RE: 50-52 PHILLIP STREET, SYDNEY – TRANSPORT IMPACT ASSESSMENT PEER REVIEW

GTA, now Stantec has been engaged to complete a peer review of the Traffic Impact Assessment (TIA) prepared by Arup dated 21 December 2020 to accompany the Stage 1 State Significant Development Application (SSD-10464) for 50-52 Phillip Street, Sydney.

**BASEMENT 1 PLAN**  
 BUILT - 50 & 52 Phillip Street

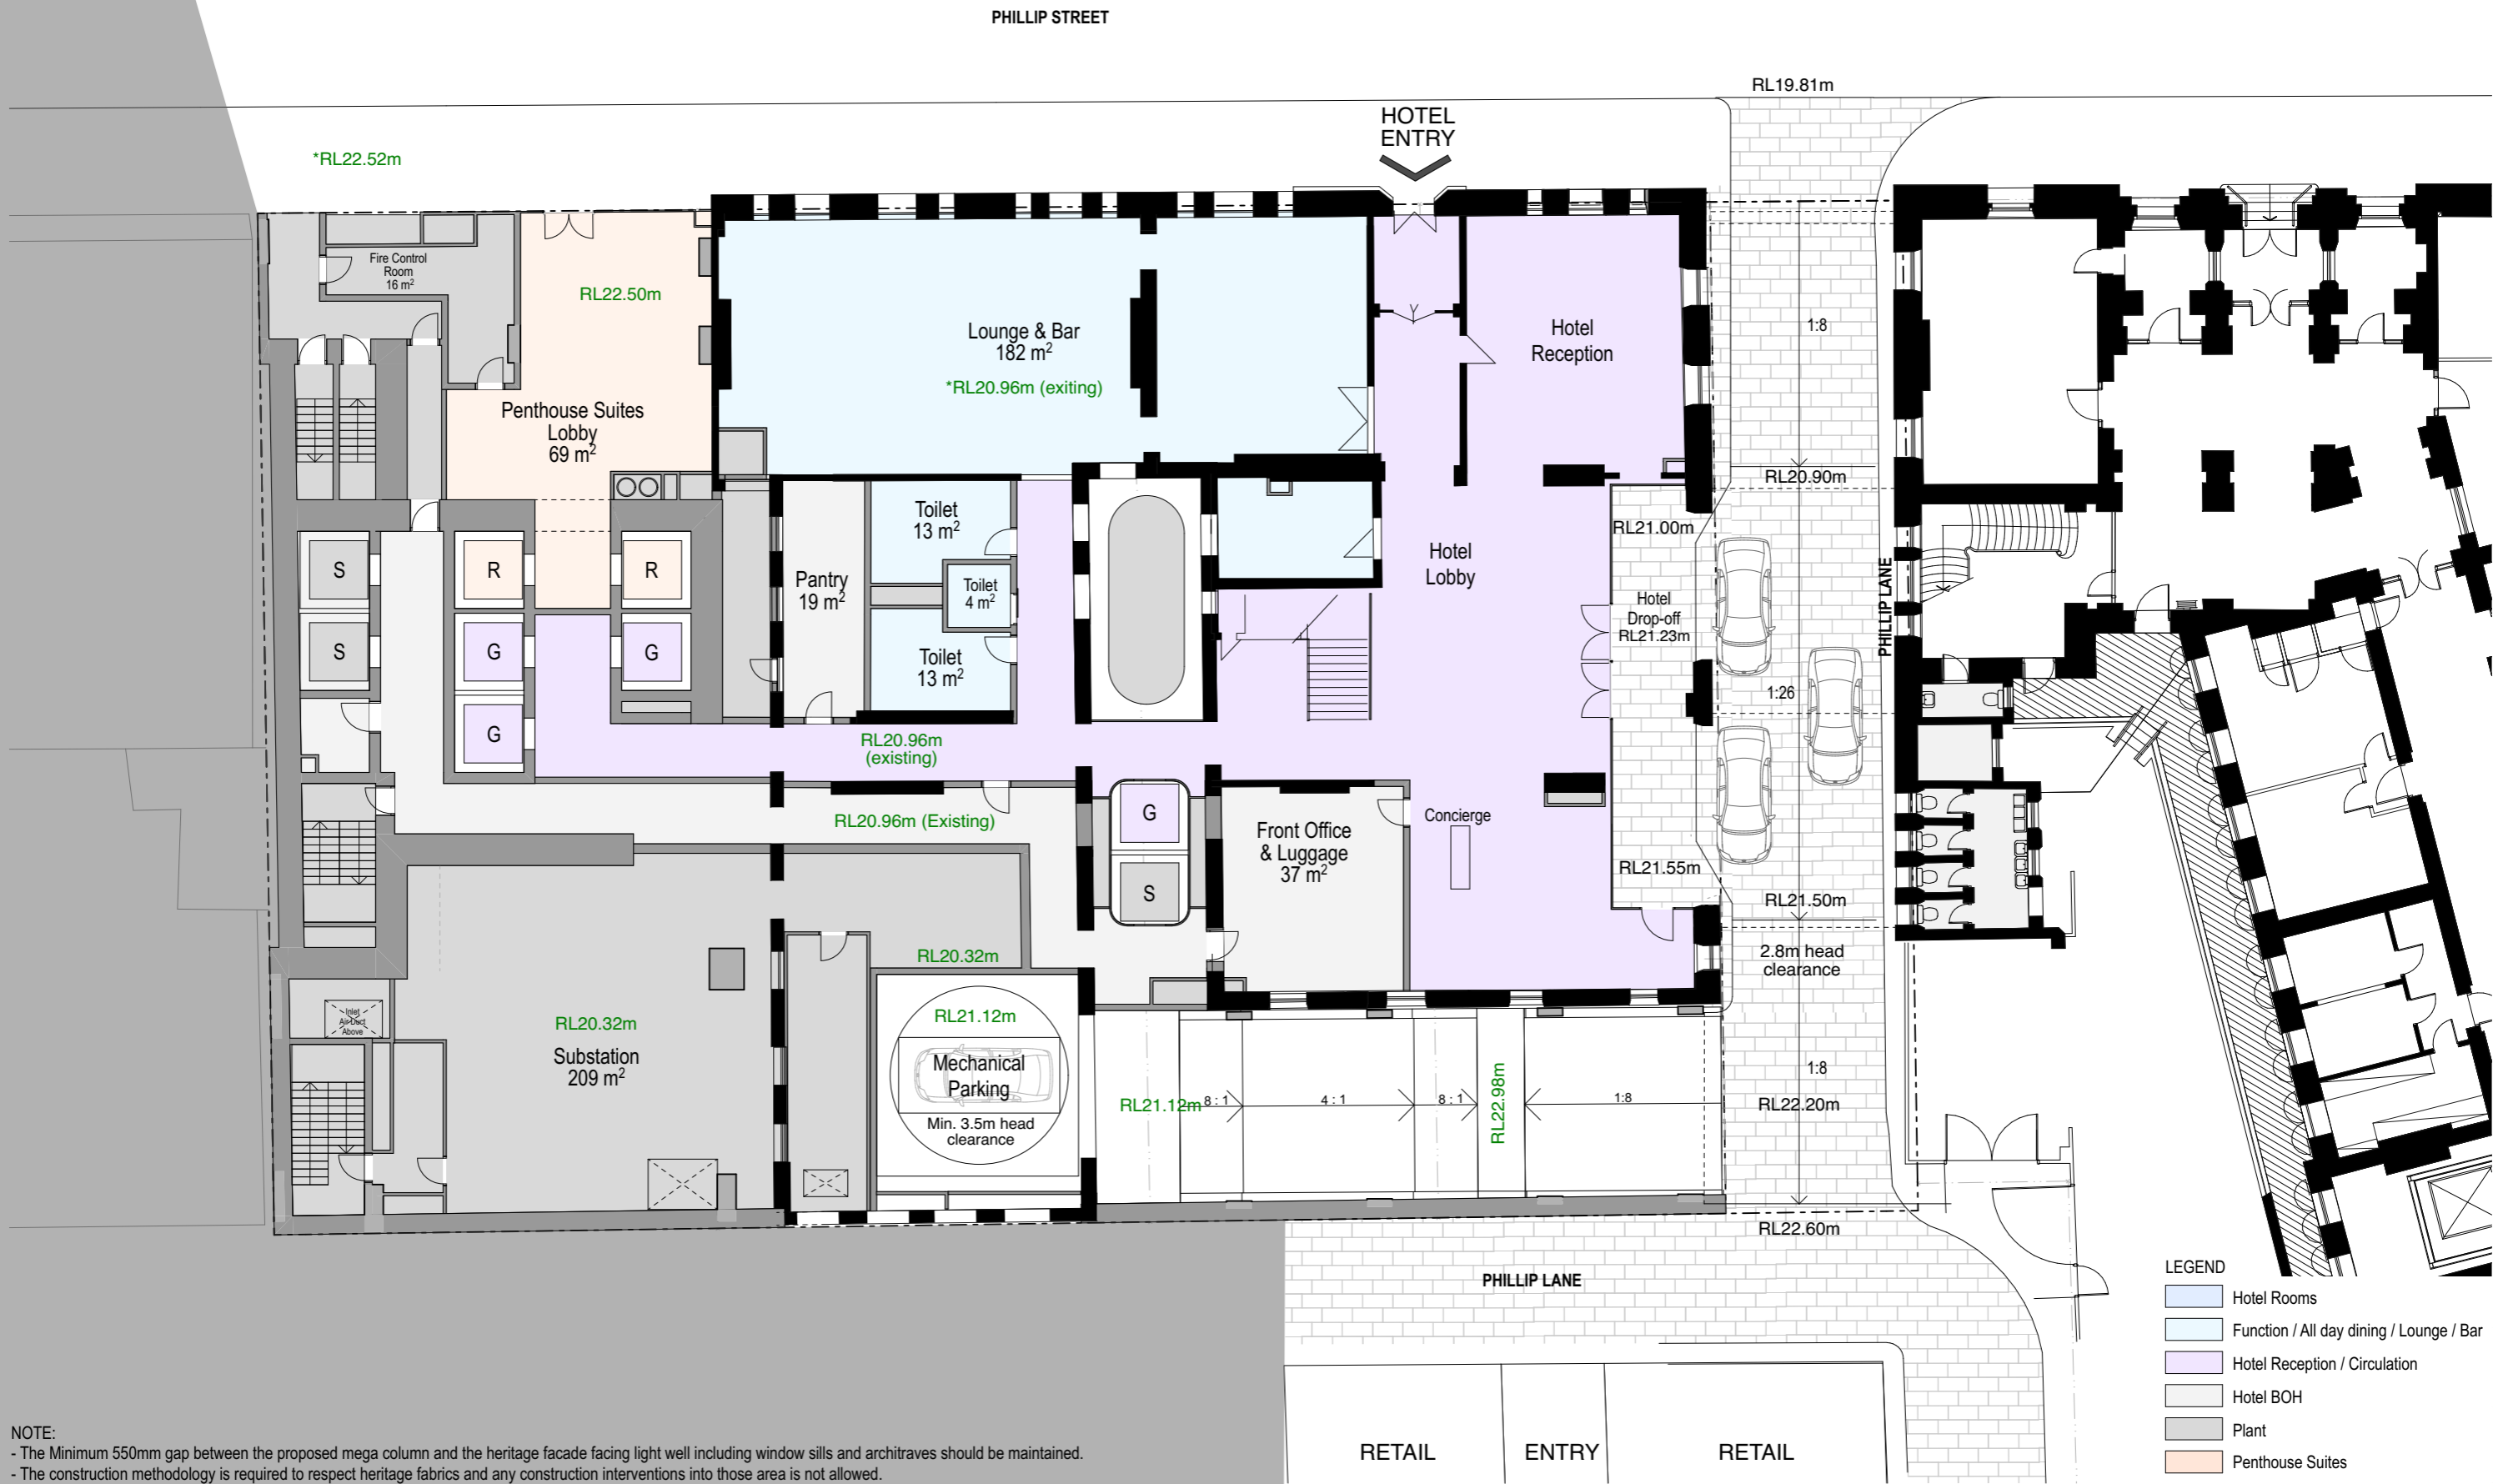
- The swept paths for 99th percentile vehicles entering the car stacker lift indicates structure within the minimum clearances. The ability for two cars to pass on the access driveway has also not been demonstrated with swept paths overlapping, vehicles having to drive on the incorrect side of the driveway, and non-compliant sightlines all matters that should be better addressed (see Figure 2 below). A 99th percentile car passing an 85th percentile car should be demonstrated, with appropriate clearances. If not achievable, then management measures to ensure appropriate and safe use is necessary.

- Queuing of vehicles should not occur on a ramp steeper than 1:20 as per the requirements of AS/NZS2890.1:2004. The current ramp design does not meet these requirements nor does the assessment consider measures to manage such access requirements. It is recommended that management measures be detailed to ensure passing of vehicles and queuing arrangements to confirm practical use when two cars do need to pass in this area (without the need for reversing and/ or conflict).

- No queuing assessment has been completed for the car stacker system to determine the number of waiting bays required for entering vehicles. While traffic generation related to the residential apartments is expected to be low, it is noted that there are five levels of stacked parking and therefore there the

- General access and circulation given poor details and presentation of the swept paths.
- The current design of the ramp does not provide an adequate length for a vehicle to queue at an appropriate grade in the event that the car stacker is in use when a vehicle arrives to enter.

- Although residential traffic generation is likely to be minor, a queuing assessment should still be provided for the car stacker noting that wait times will likely be significant for inbound vehicles in the event that the stacker is already processing a car travelling between the entry level and the bottom level of the car park or vice versa. The total vertical travel distance is around 11.75 metres and this should be defined to confirm delay generally.

**LEVEL 1 PLAN**  
 BUILT - 50 & 52 Phillip Street

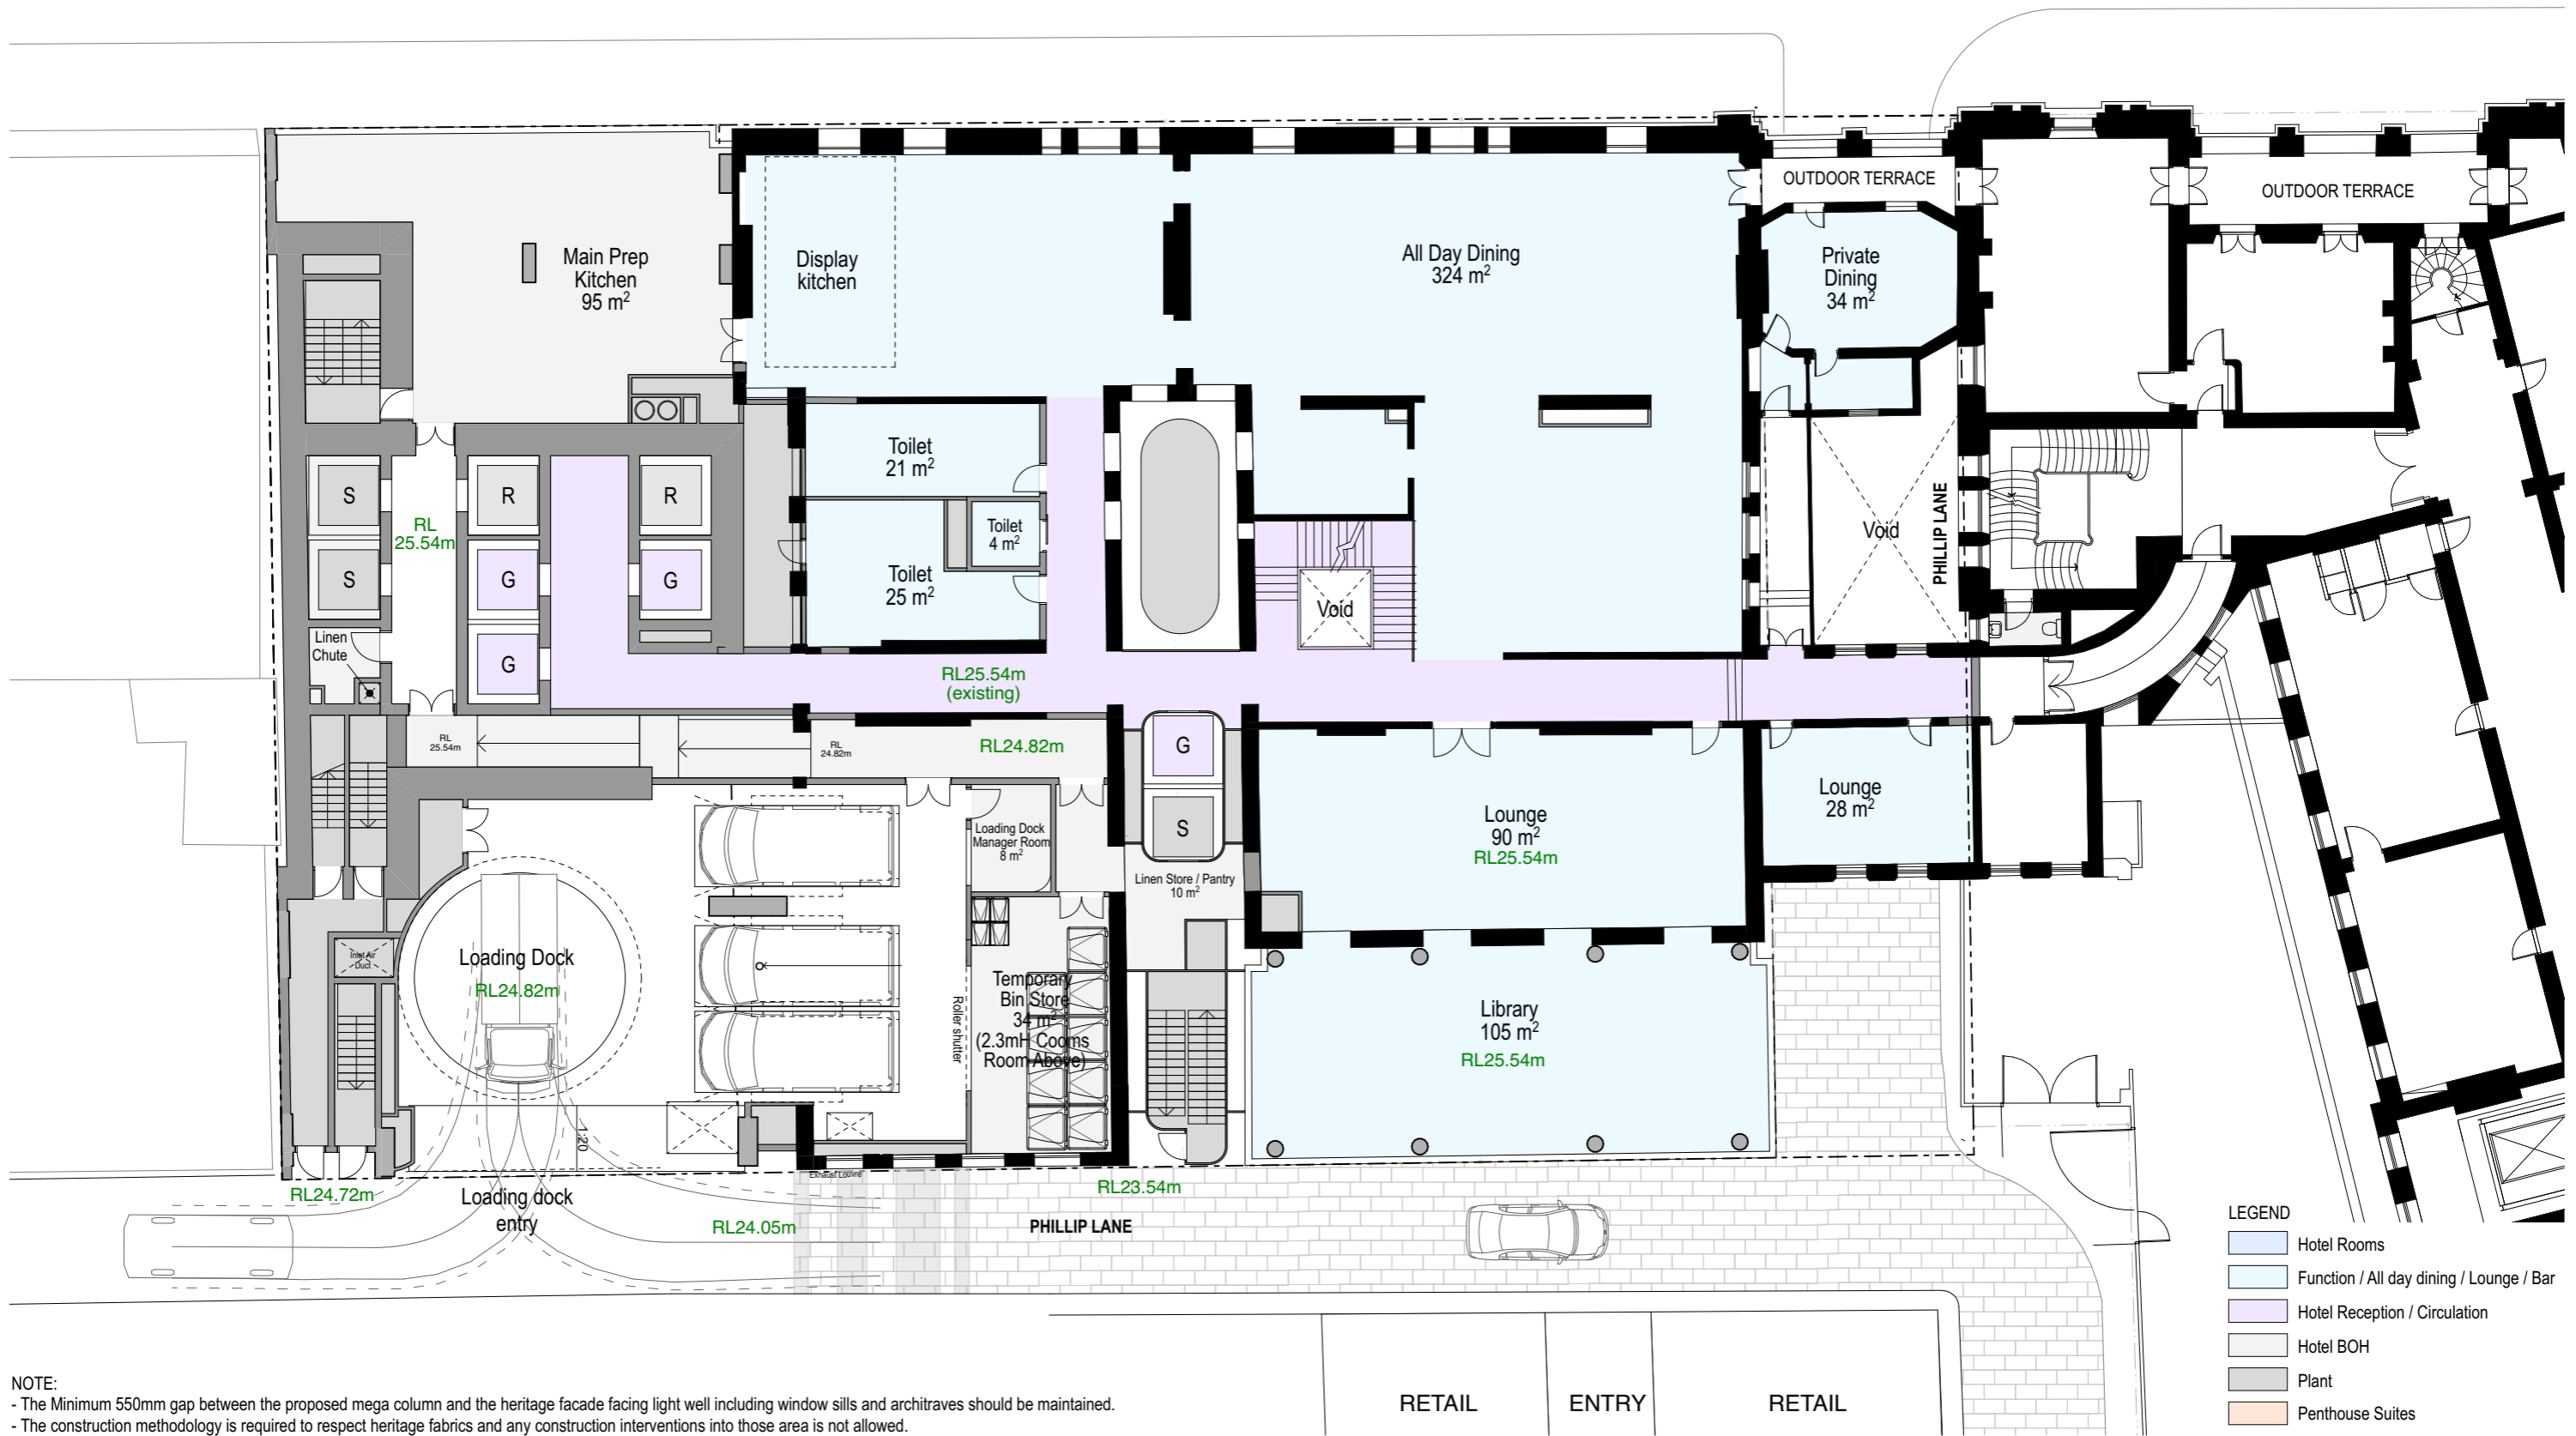
- The swept path assessment provided in Appendix D of the TIA (Arup, 2020) has not demonstrated that vehicles on the northern laneway would be able to pass vehicles in the porte cochere. This would likely result in congestion and interruption (at best) to through traffic in this area. Impacts to southbound traffic on Phillip Street is also a risk in this regard.

- The swept paths indicate structure would be within the minimum service vehicle clearances when manoeuvring in and out of the loading bays and on the turntable. Improved swept paths, separated by movements (not all on the one plan) should be provided to ensure access and manoeuvring is appropriate and able to meet relevant Australian Standards, including necessary clearances on the turntable.

- The architectural plans show function rooms on Level 3. No assessment has been made of the traffic impact of a function being held on site. Functions typically result in a more intense period of traffic generation before and after the event. As such, there may be potential for demand to exceed the capacity of the porte cochere capacity for these events. This in turn would impact traffic flow on the northern laneway and may also impact traffic flow on Phillip Street.

- The swept paths should be updated to confirm the following:
 - Vehicles on the northern laneway can pass any vehicles parked within the porte cochere.

- Access to each loading bay can be achieved without structure compromising the necessary vehicle clearances.
 - Exiting vehicles from the car stacker can pass any queued inbound vehicles waiting to enter the car stacker.
